From: Dayle Bennett <DBennett@wsairport.com.au>
Sent: Friday, 11 July 2025 3:55 PM
To: Sally Munk; Andrew Watson
Cc: Planning and Safeguarding; Kirk Osborne; Natasha Williams
Subject: RE: [SEC=OFFICIAL] FW: Notice of Exhibition - Badgerys Creek Industry Park (SSD-74191717)

Apologies for the delay in coming back to you. Thank you for the opportunity to comment on the Environmental Impact Statement (EIS) SSD-74191717 for Badgerys Creek Industry Park located at 85 Martin Rd, Badgerys Creek. We understand that the proposal comprises:

- Staged development consent for up to 4x warehouse and distribution centres.
- Stage 1 includes three warehouses with ancillary offices and parking for 294 cars, associated services, temporary stormwater via on-lot OSD basins/wetlands and landscaping.
- Stage 2 seeks to remove the temporary stormwater and landscaping, to construct warehouse 4 with an ancillary office and 134 additional car parks.

Figure 7 Site Location and Western Sydney International Airport ANEC

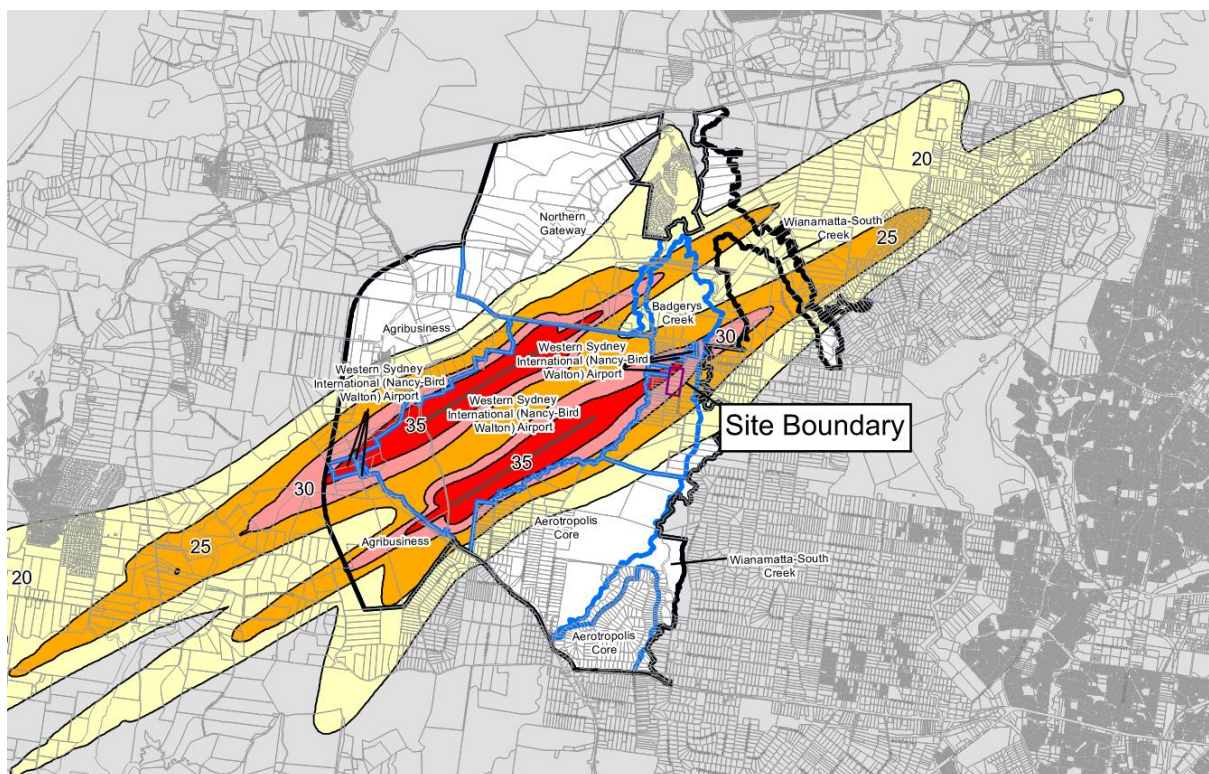
Impact	General Comments
Aircraft Noise	
Warehouse buildings	The site is located within ANEC/ANEF 30 to 35+ for the future second runway and must comply with Australian Standard 2021: 2015 to achieve specified indoor sound levels. The Australian Standard 2021 that ‘other industrial’ activities are acceptable within all ANEF zones and the applicant considers the proposed warehouses are considered to ‘other industrial’ uses The applicant should be aware aircraft overflight will occur in the site’s vicinity any time of the day or night and the buildings should be treated with the appropriate acoustic attenuation.
Wildlife Hazards
